Please ask for: Mrs D Johnson
Email: daun.johnson@arun.gov.uk
Telephone: 01903 737762
Our Ref: LU/10/25/PL
Your Ref:
Date: 20th January 2025

Application for Planning Permission

Development: Demolition of existing extension from the existing shop small and construction of a 2 storey larger extension to enlarge the floorspace of the existing shop premises, with additional added office/storage space on 1st floor. This application is in CIL Zone 4 (Zero Rated) as other development.
The proposed extension, will be timber frame construction, with modern cladding to outer walls, upvc doors and windows, with flat roof including roof light, new toilet to groundfloor area to rear position. Stairs will be moved back from existing location, to enlarge salesfloor area, to retain commercial/retail businesses in this vibrant area

Location: 78 Flat Wick Street Littlehampton BN17 7JS

Proposed Floor Plan

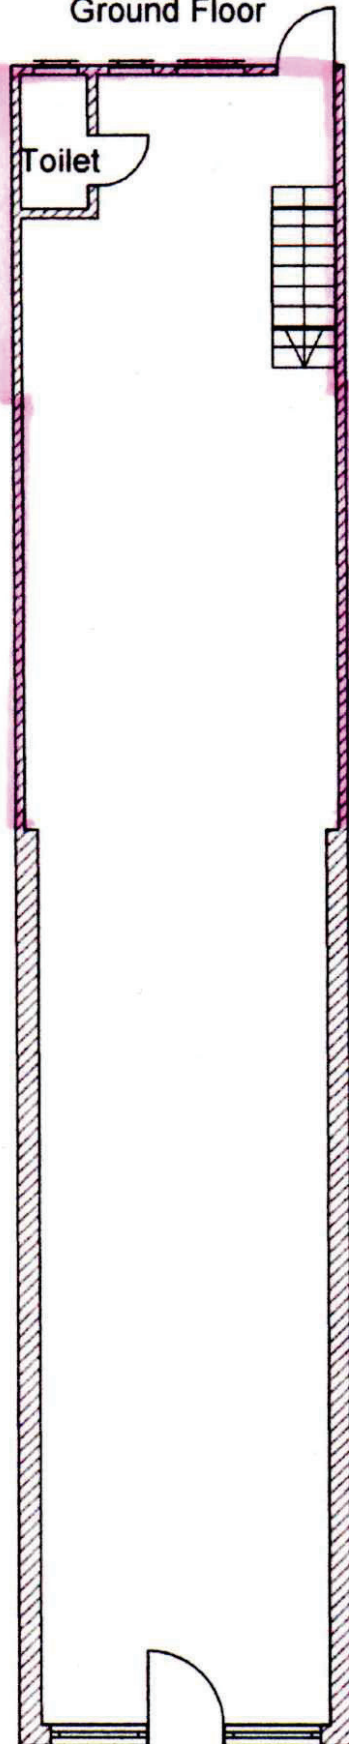
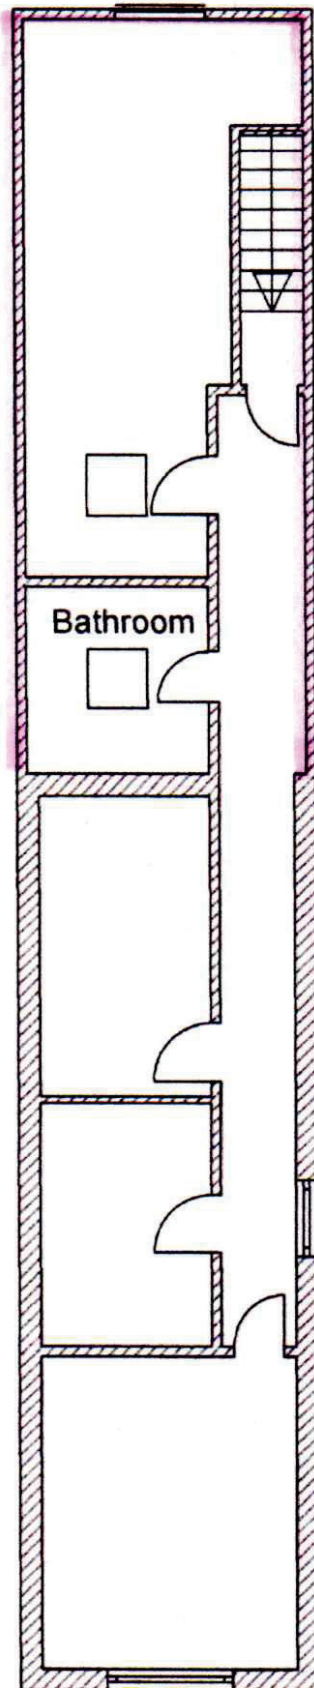
On the proposed floor plan, please highlight/hatch what is being proposed.
